I am emailing in response to File AL-17-027 Parcel ID 52190-00-032

**From:** Courtney Gallentine <courtvolle@hotmail.com>  
**Sent:** Wednesday, December 6, 2017 5:45 PM  
**To:** Len Kendall  
**Subject:** Fwd: File# AL-17-027 Parcel ID# 52190-00-032

**From:** Courtney Gallentine <[courtvolle@hotmail.com](mailto:courtvolle@hotmail.com)>  
**Date:** November 29, 2017 at 2:57:42 PM MST  
**To:** [lenkendall@elpasco.com](mailto:lenkendall@elpasco.com)  
**Subject:** File# AL-17-027 Parcel ID# 52190-00-032

SITE PLAN

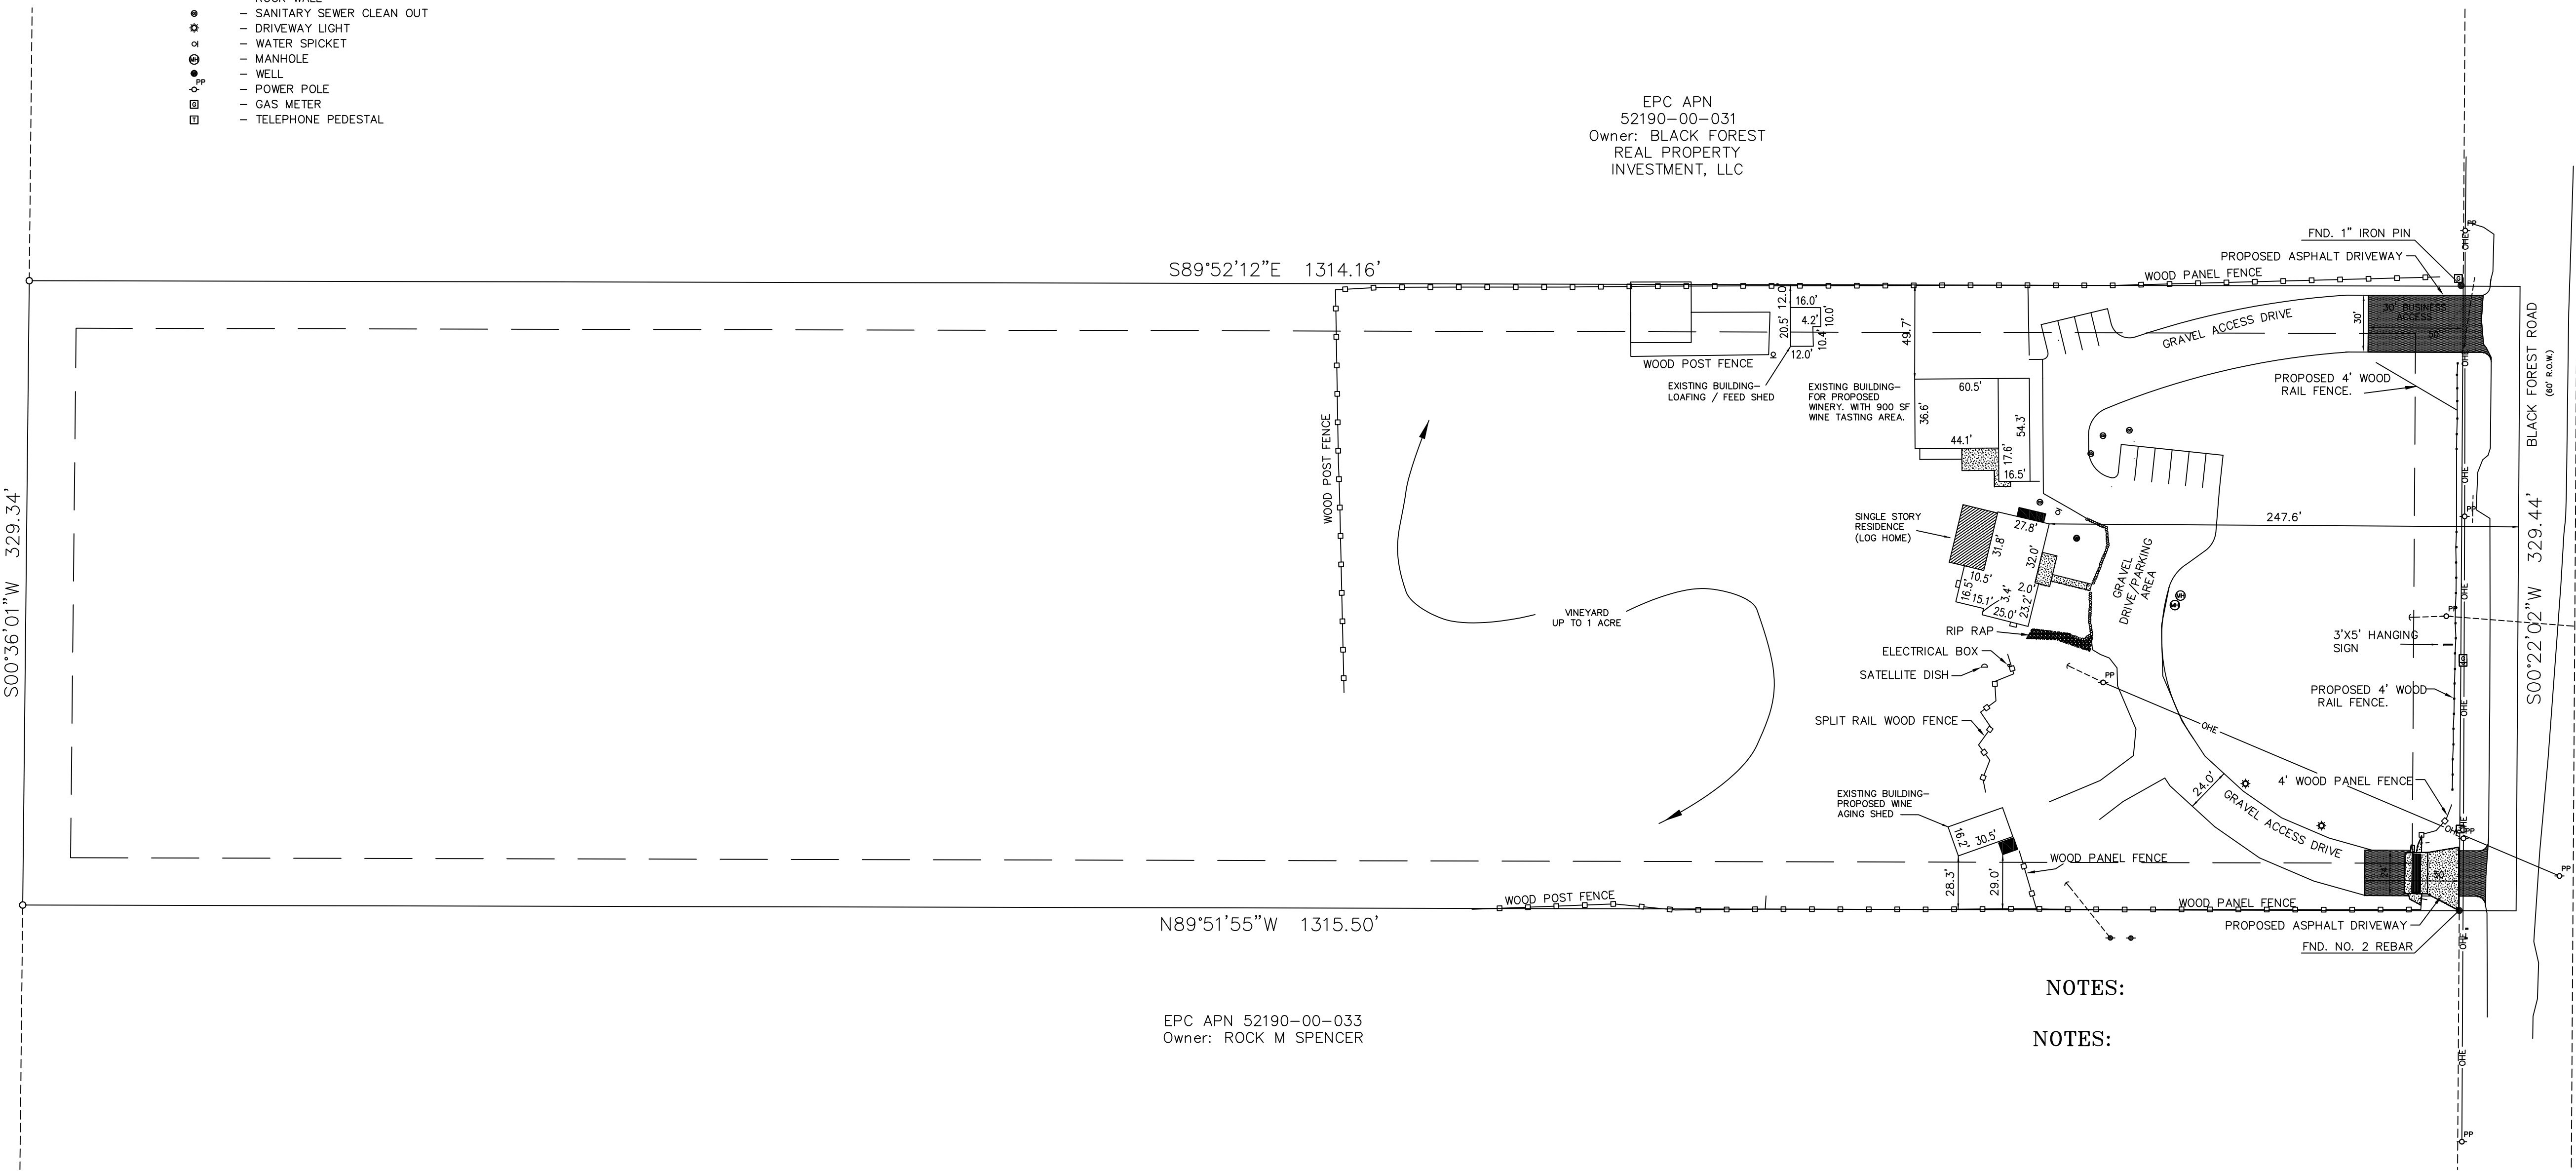
2. The drawings and plans that have been presented to us continue to show the primary access to this business would be through our property. It's important to note that the "street" Naylor, on the drawing is actually a dirt road by technical standards but in reality is a shared driveway for our home and our neighbor's. An increase of traffic, parking, and visitors on our driveway would have a huge effect on our home. We would request that the space be surveyed and that no traffic (by vehicle or foot) be allowed on the property we have owned for more than 25 years.
